TO:
City of Mercer Island
Community Planning and Development
Permit #1808-172

DATE:
August 20, 2020

We have made the following post permit revisions to the project. Please see the attached plans for reference. We look forward to your review and approval

MZA ARCHITECTURE  
**PAEK RESIDENCE**  
 DRAINAGE & GRADING PLAN  
 CITY OF MERCER ISLAND, WASHINGTON  
 JOB NO.: 1954-003-018  
 DWG. NAME:  
 DESIGNED BY: BML  
 DRAWN BY: BML  
 CHECKED BY:  
 DATE: 01/14/2021  
 DATE OF PRINT:  
**C2**  
 OF SHEETS

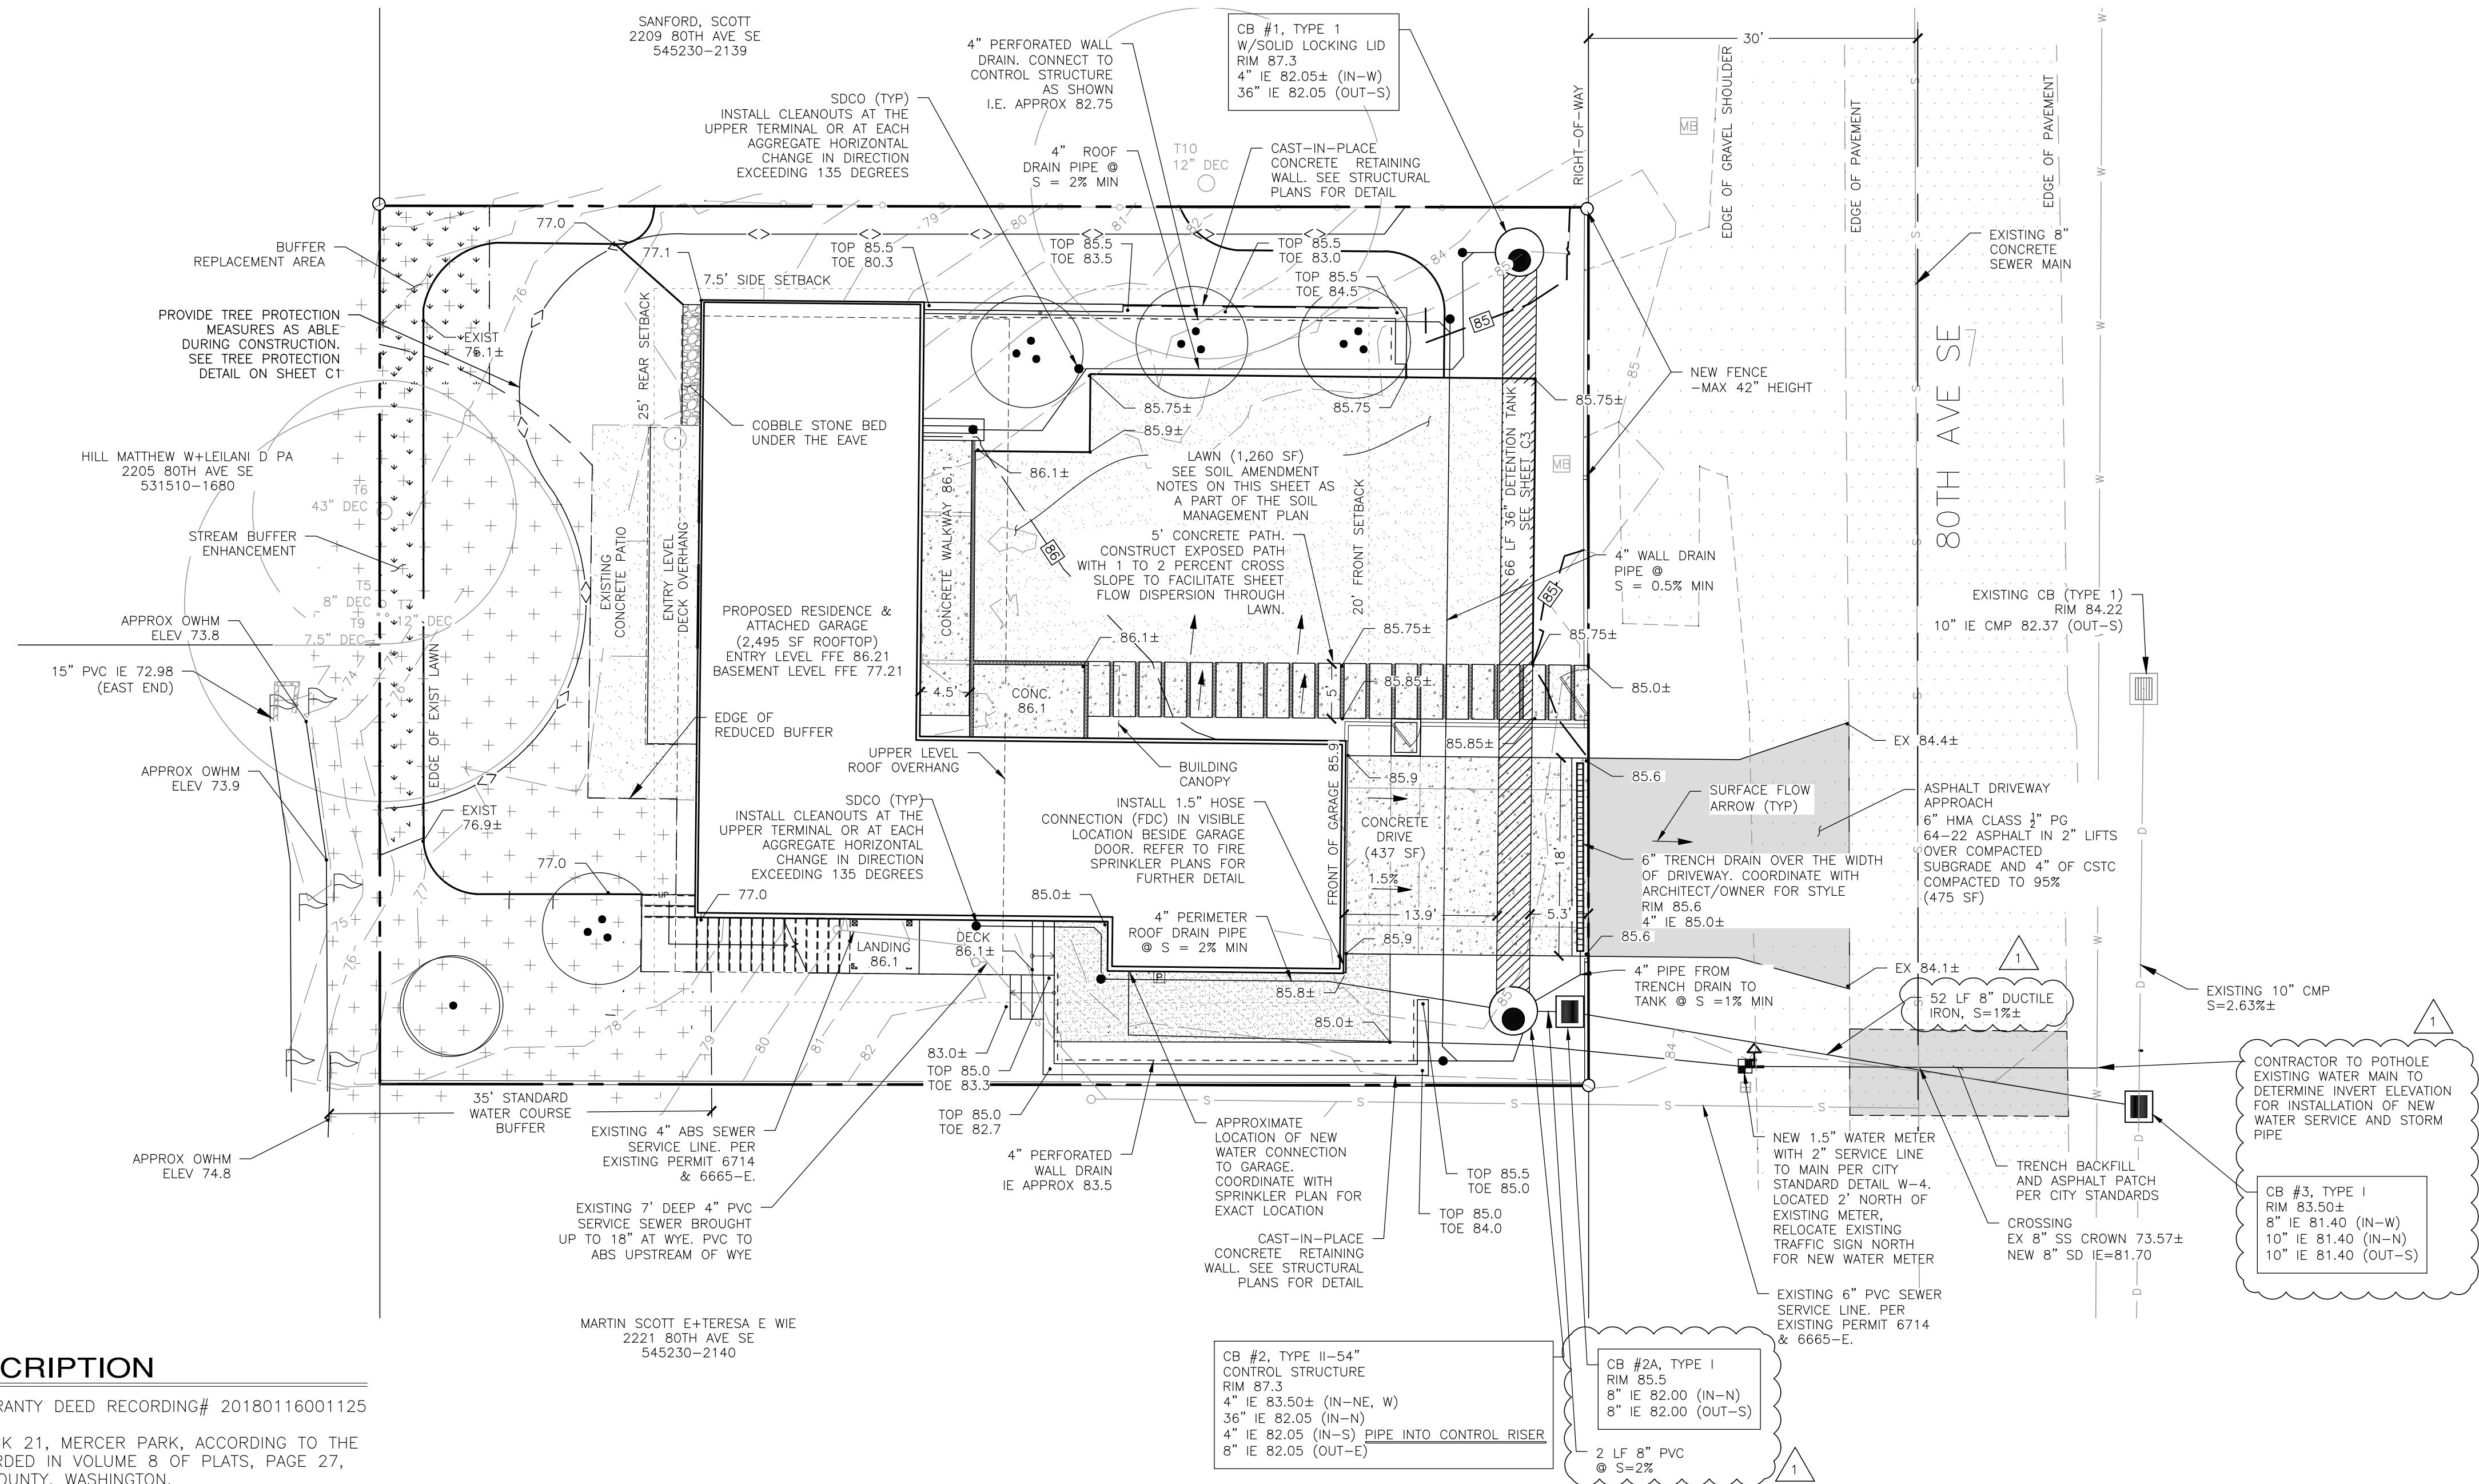
- 2) The at-grade patio on the west side has been added back into the project. This is an existing patio that was scheduled to be removed in the prior plan set but the owner has decided they would prefer to keep it. The lot coverage/hardscape calc have been updated accordingly. The environmental engineer provides the following explanation:

1 EAST ELEVATION
Scale: 1/4" = 1'-0"

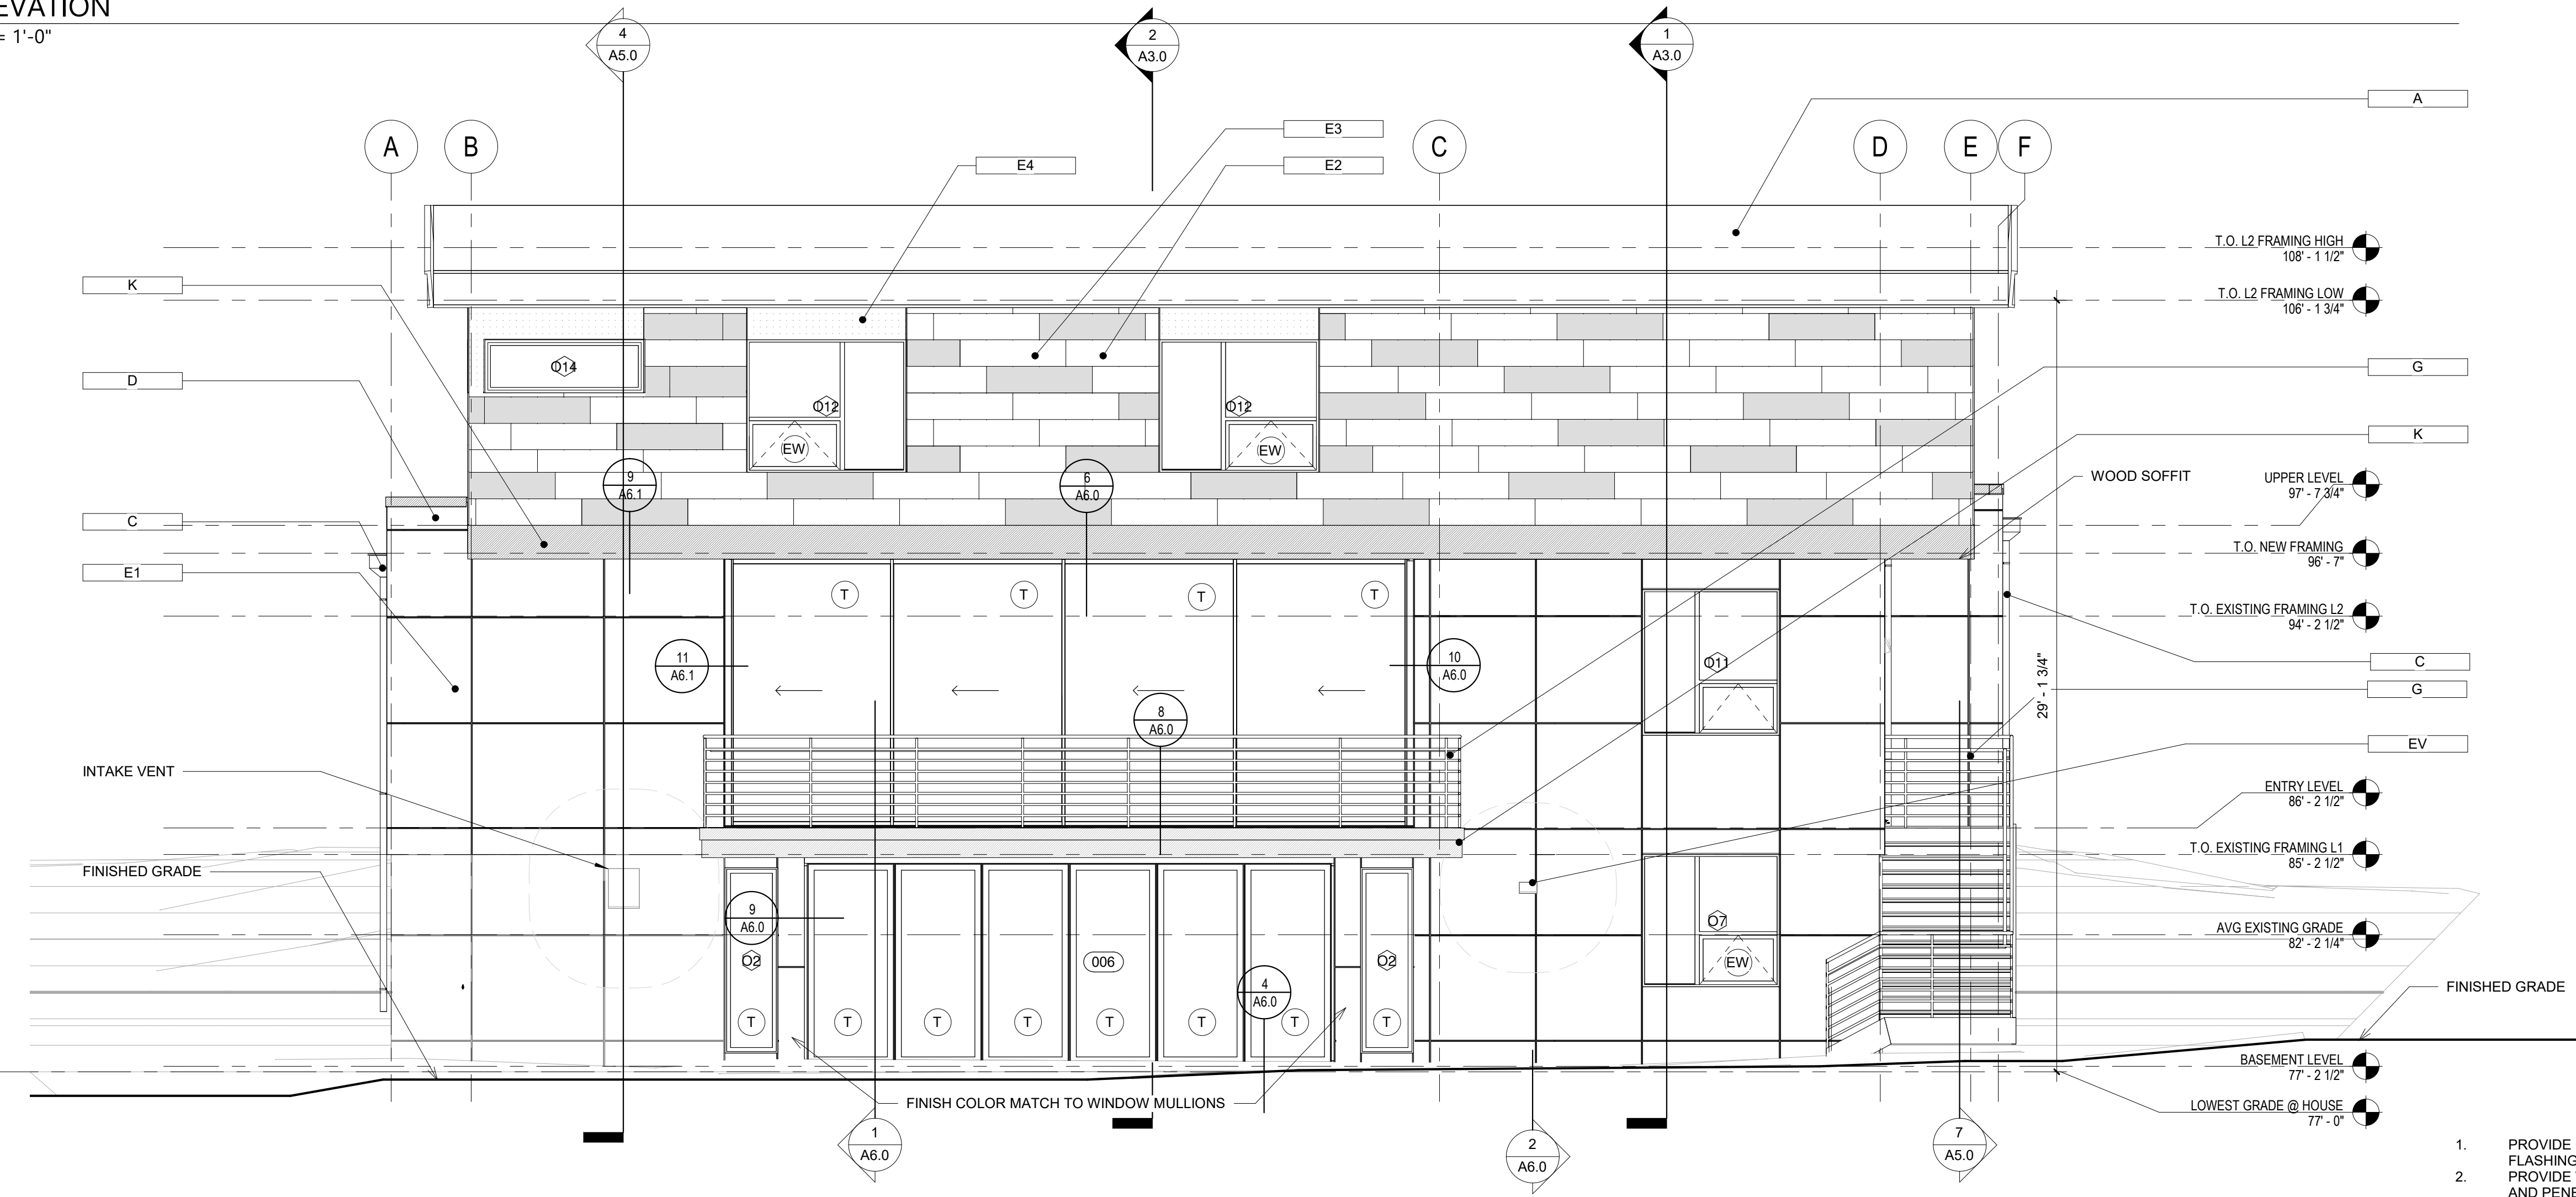
- c. Location and size of folding door at the basement level
 - d. Windows on upper level east elevation and one added on the west elevation
 - e. Other misc soffit
